Technical Memorandum – Victoria Cross ISD, SSSA Traffic & Green Travel Plan

Date:	27 March 2020
To:	Michael James (LendLease), Lulu Woods (Lendlease)
Cc:	Greta King (LendLease) Stephen Canty (ARCMAC)
From:	Nicole Vukic
Reference Document Numbers:	SMCSWSVO-LLC-SVC-TI-REP-000001, SMCSWSVO-LLC-SVC-TI-REP-000002

This technical memorandum responds to comments and recommendations within submissions made on the Victoria Cross OSD Detailed State Significant Development Application (SSD-10294), including the Transport for NSW (TfNSW) submission dated 20 December 2019 as well as relevant public submissions.

Appendix A: Swept path analysis

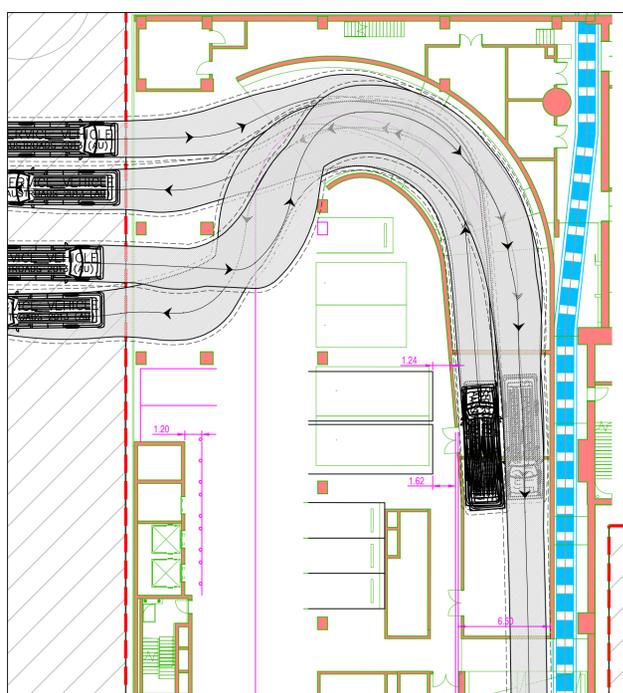
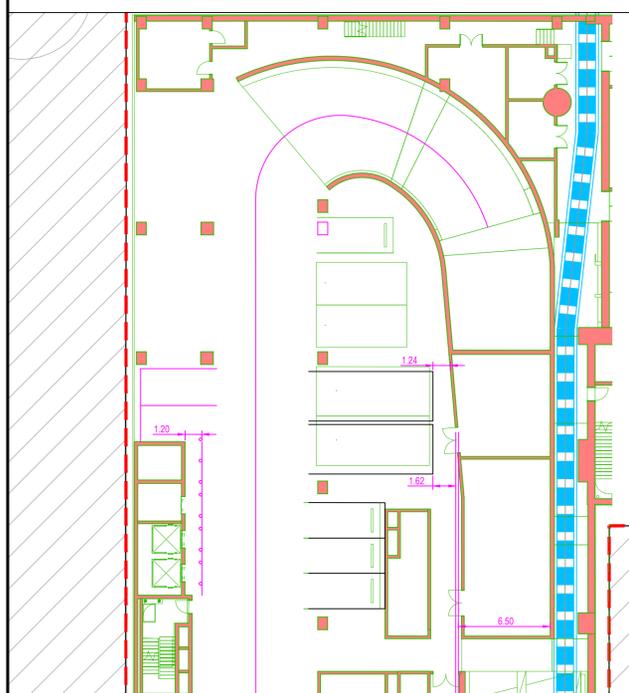
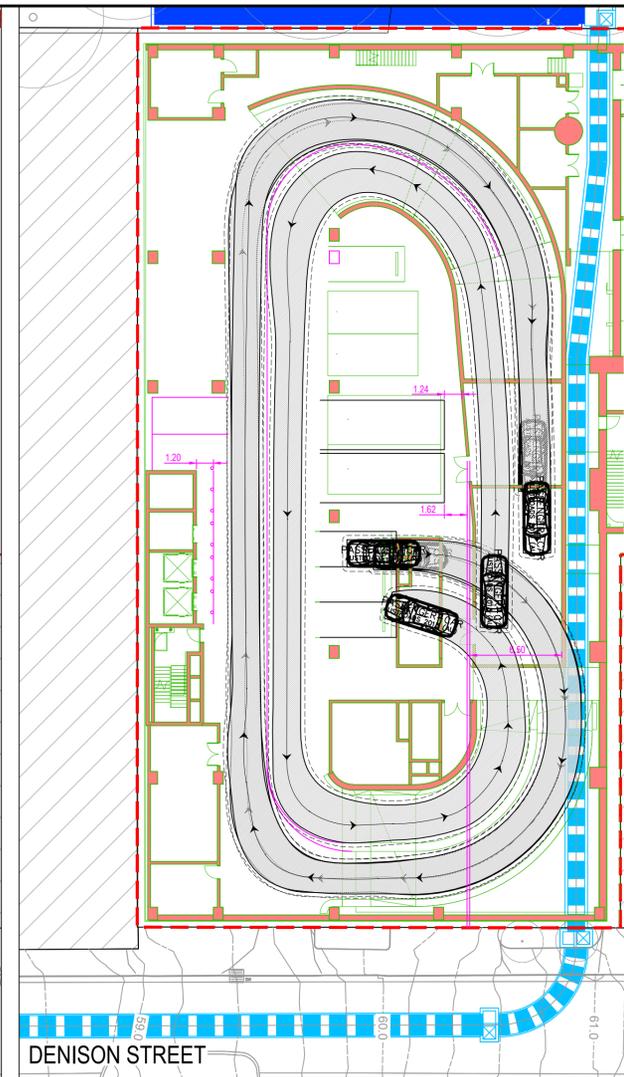
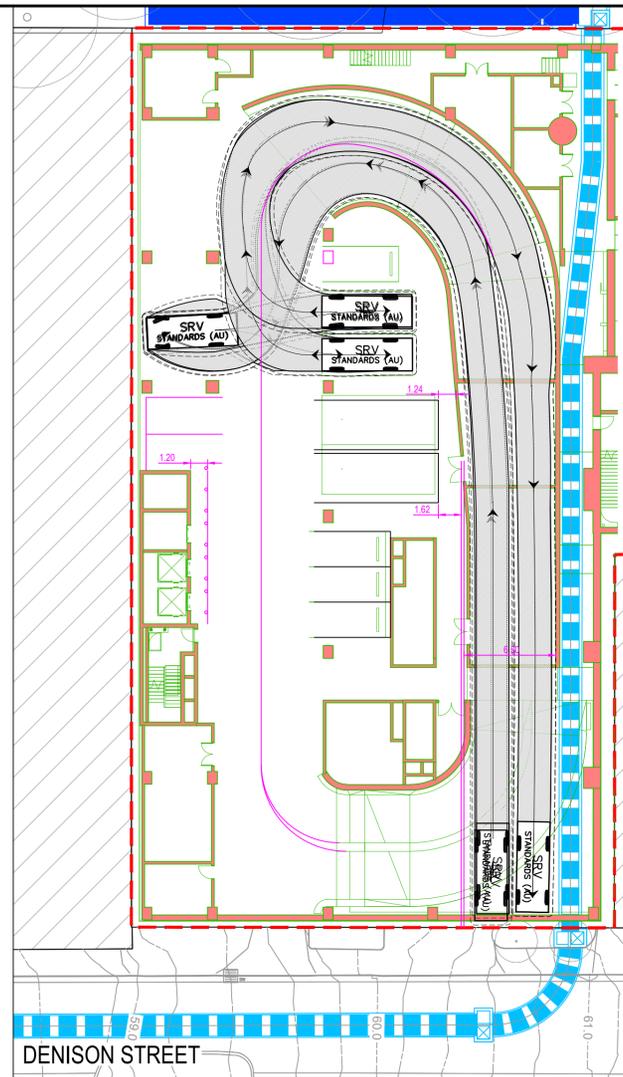
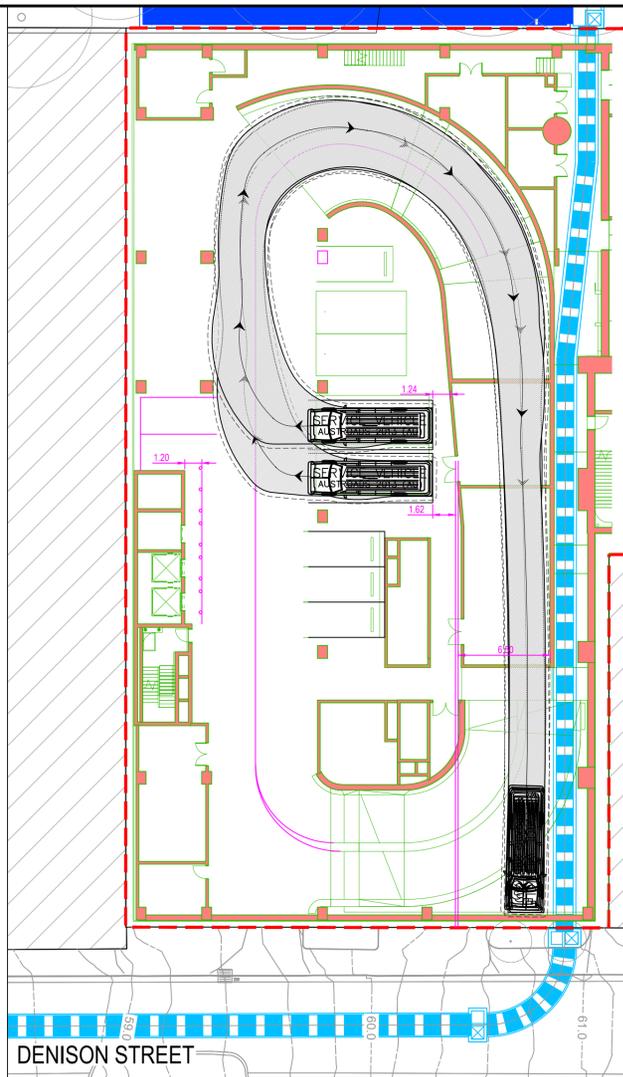
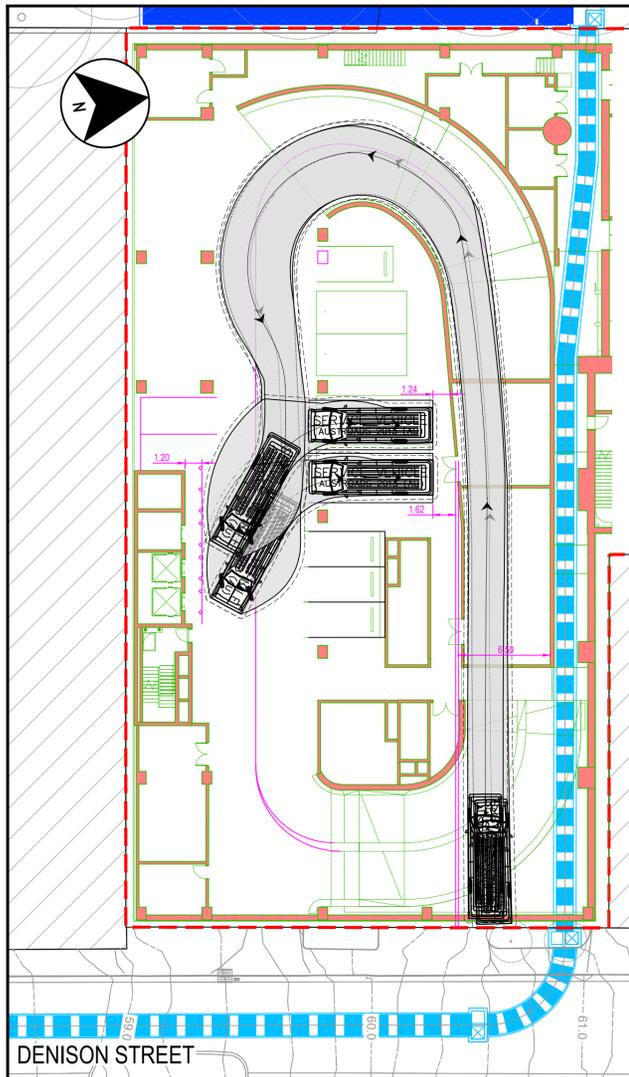
Further information should be provided on the future MLC breakthrough

As detailed in the architectural and structural design (refer to Figures 1 and 2) of the basement loading dock area, the proposed design allows for a future breakthrough into the adjacent MLC basement, for the connection of vehicle access via a shared loading dock as required in the Sydney Metro Victoria Cross Scope of Works and Technical Criteria (SWTC). This design is completed as part of the station works under the Critical State Significant Infrastructure project (CSSI) approval which includes the construction of all works below ground or above ground improvements with the metro station structure for appropriate integration with the OSD.

Swept paths have been completed for the proposed connection locations to the MLC at loading dock level to inform the Victoria Cross basement design as shown in appendix A of the OSD Detailed

SSD DA – Traffic and Transport Impact Assessment Doc No. SMCSWSVO-LLC-SVC-TI-REP-000001.
